CITY OF PORTLAND, MAINE
MEMORANDUM

SUBJECT: First Baptist Church, Canco Road and Washington Avenue

DATE: 10/24/86

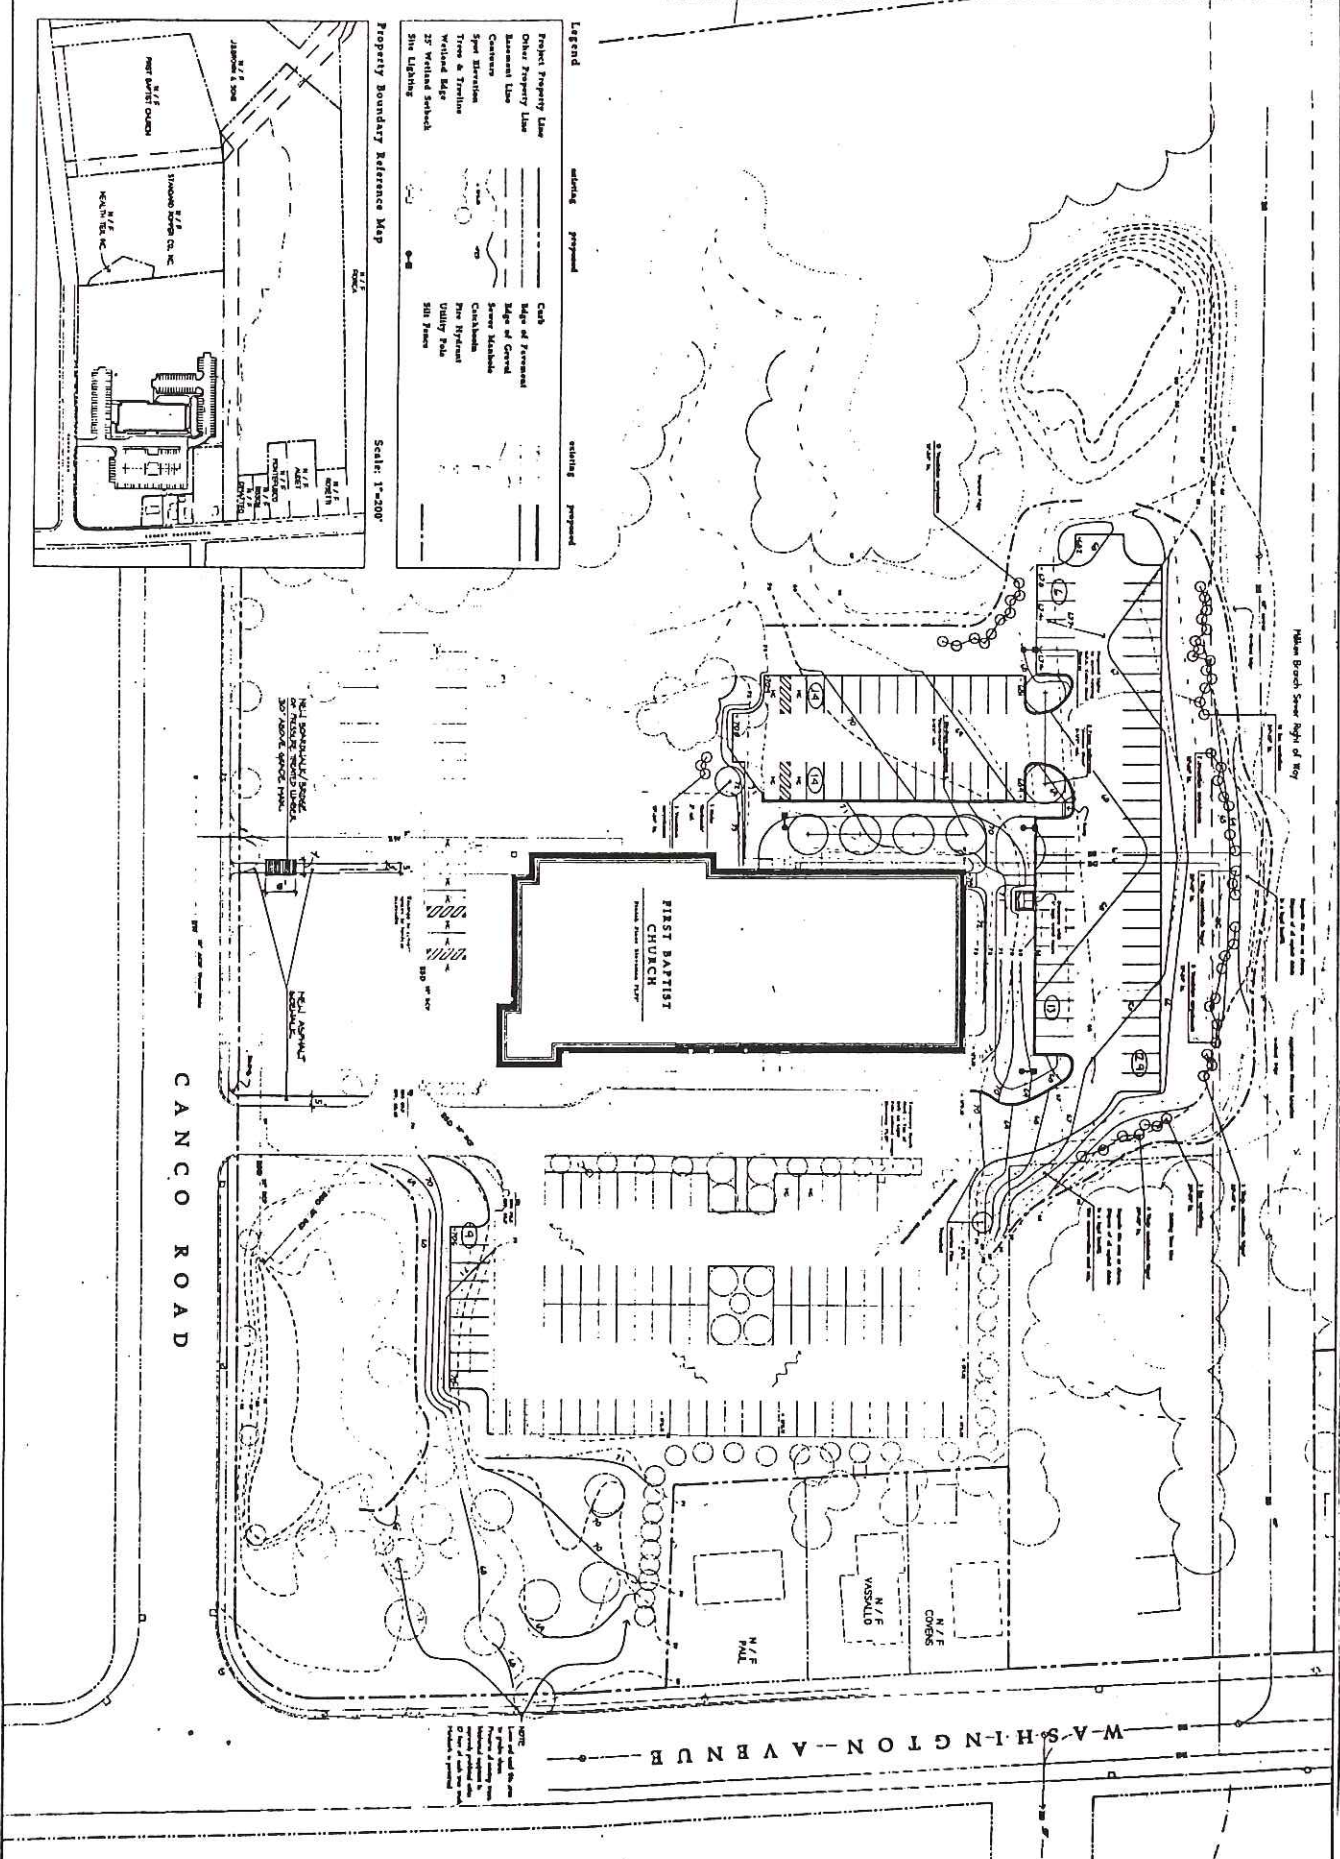
1. That the design specifications for the hydrobrakes to be installed in the catchbasins in the parking lot be indicated on the plans.
2. The sidewalk to be built along Canco Road shall be installed along the streetline with a five foot wide grassed esplanade between the sidewalk and the new curblines.

Stormwater runoff will be collected through a series of catchbasins in the parking lots and outletted into Milliken Brook, which traverses the property. Milliken Brook enters the City Interceptor Sewer on site at a point northerly of the proposed driveway to Washington Avenue.

Hydrobrakes will be installed in the last two catchbasins before the stormdrain outlets into the brook. The hydrobrake units will regulate the rate of runoff draining from the developed site during rainstorms.
